# Rezoning Transportation Analysis

Petition Number: 2020-141

General Location Identifier: Tax ID 12708701

Date	Description
10-26-20	First Review
11-30-20	Second Review (WB)
12-28-20	Third Review (WB)
02-08-21	Fourth review (WB)
02-24-21	Fifth Review (WB)
03-24-21	Sixth Review (WB/RB)

CONDITIONAL REZONING PLAN

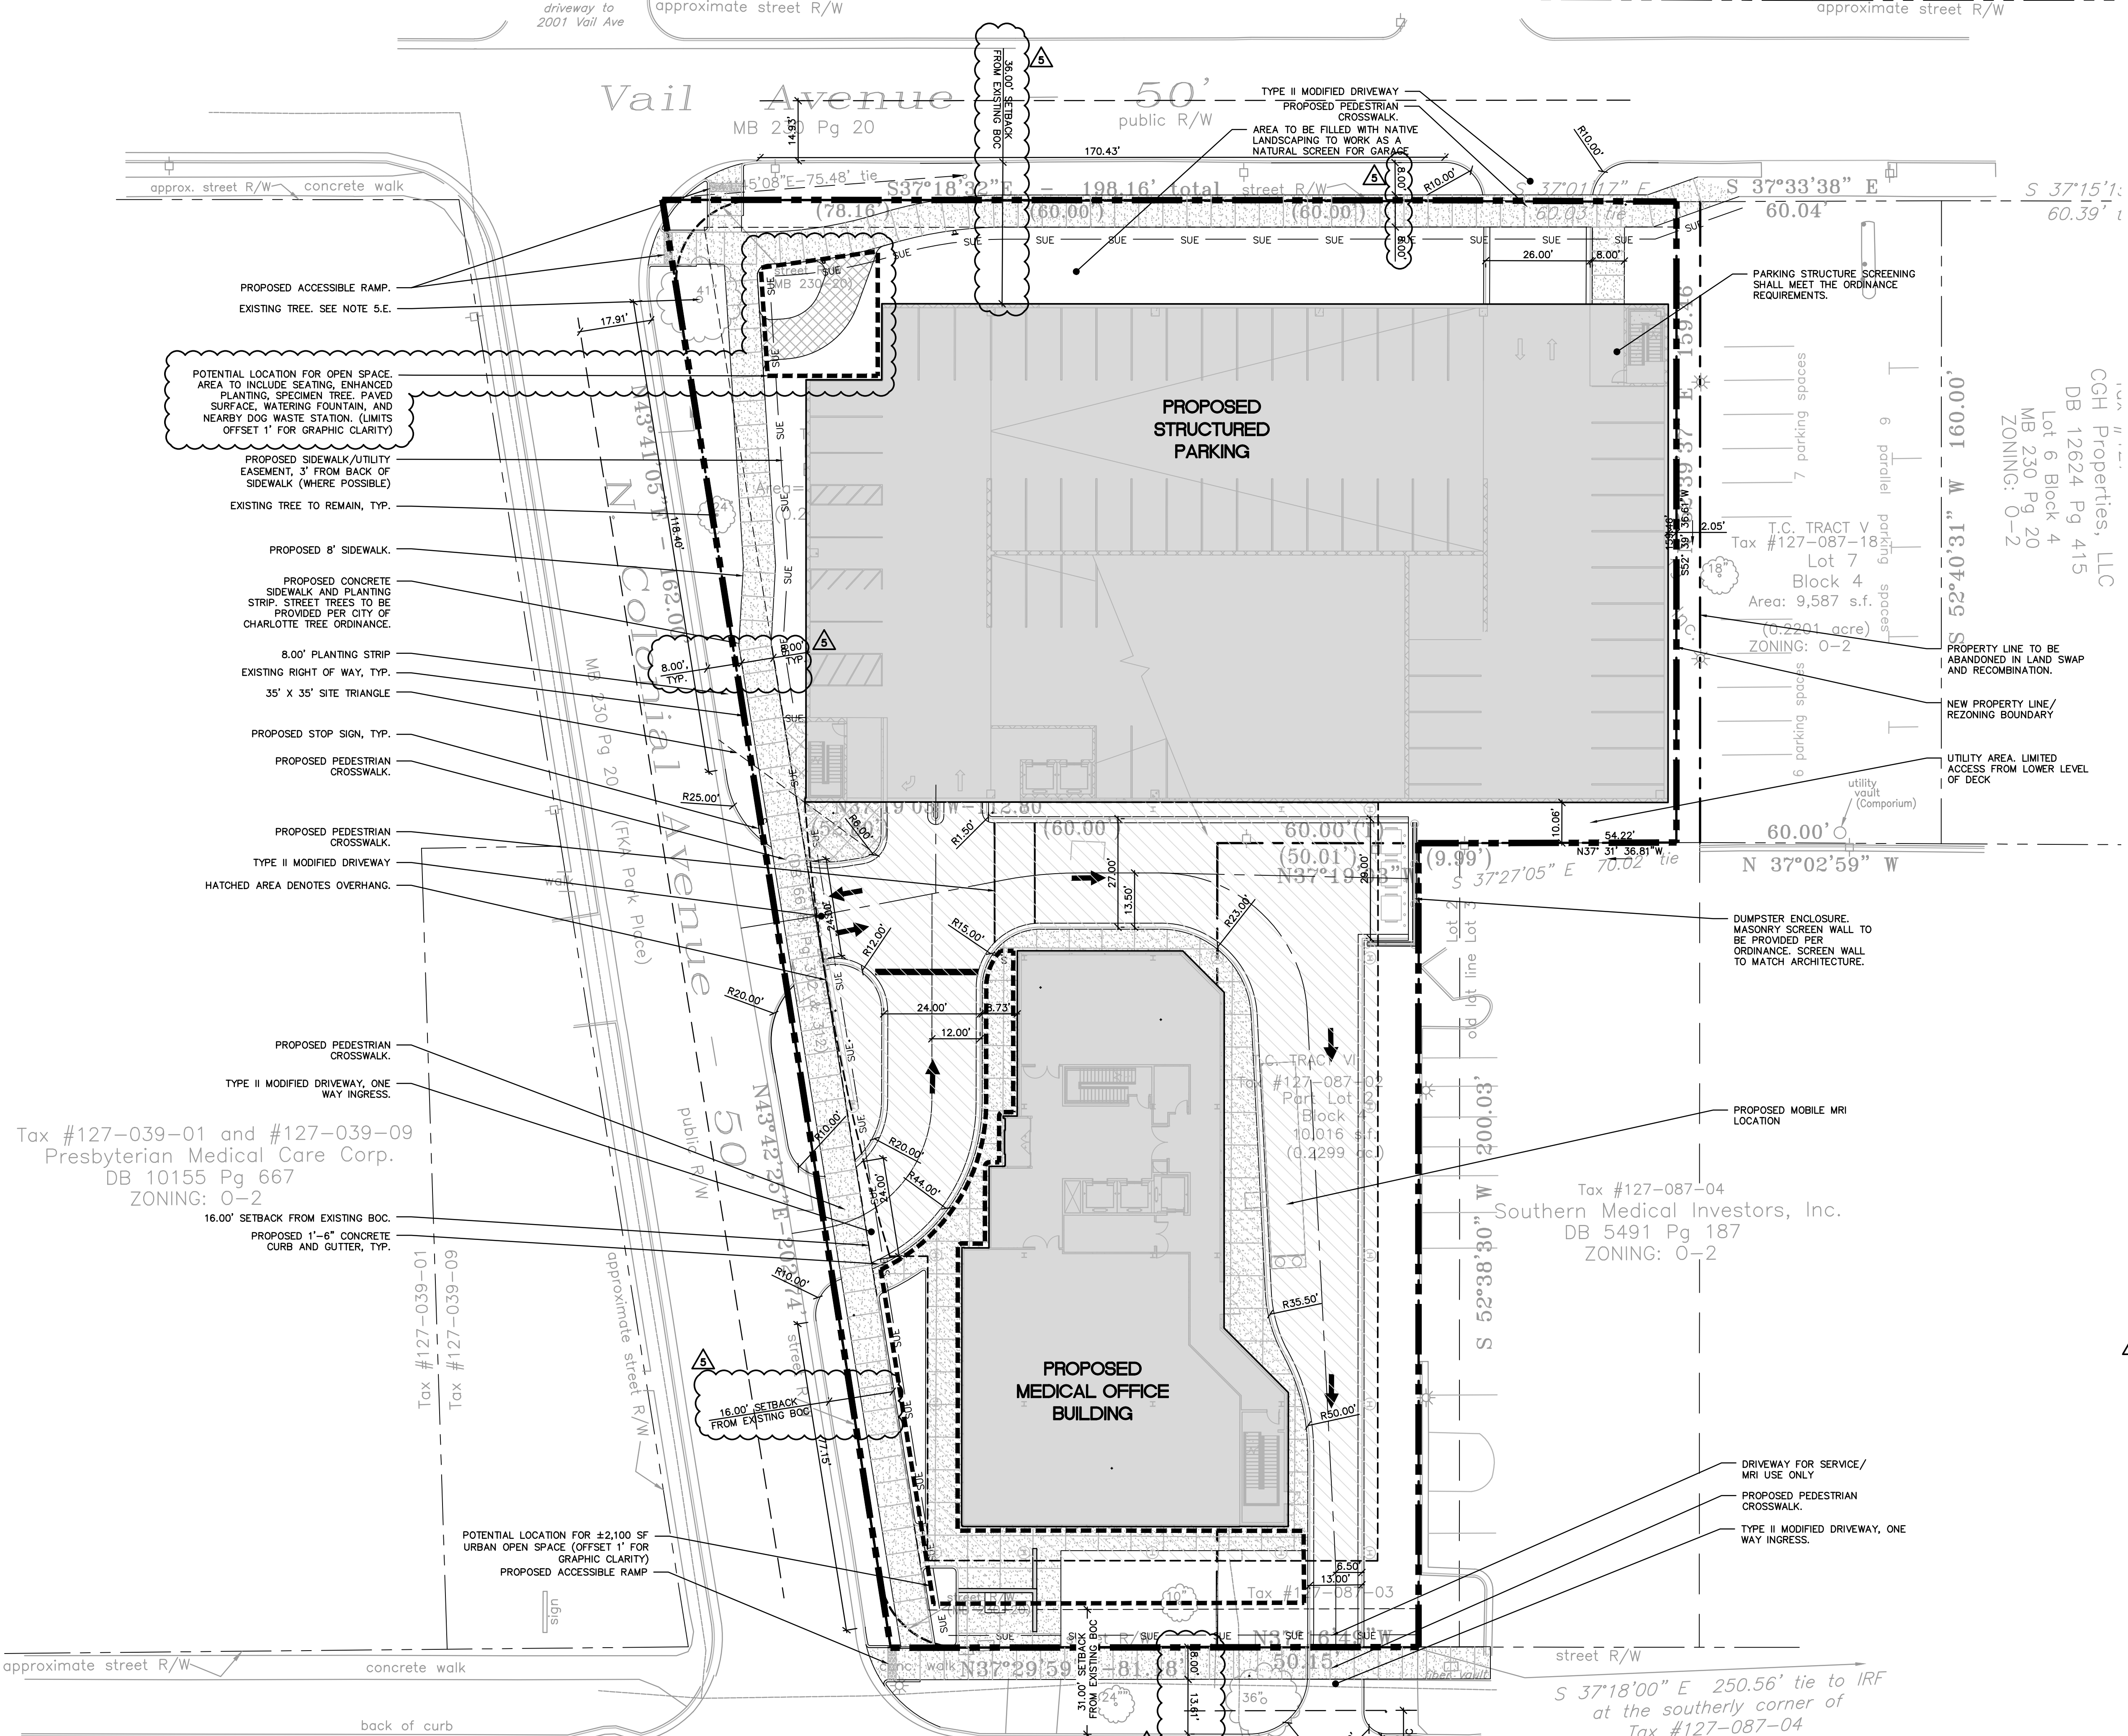
1. ~~**Curblines:** The proposed zoning district has a setback measured from back of the existing or proposed future curblines.~~

~~a. **Randolph Road:** The future location of curb and gutter is in its existing location.~~

~~b. **Vail Avenue:** The future location of curb and gutter is in its existing location.~~

~~c. **Colonial Avenue:** The future location of curb and gutter is in its existing location.~~

Label and dimension curb and gutter from the centerline for each road on the site plan.

5. ~~Revise site plan and conditional note(s) to commit to constructing an 8-foot planting strip, and 8-foot sidewalk along the site's frontage per Chapter 19. The wider sidewalk also meets the Charlotte WALKS Policy.~~
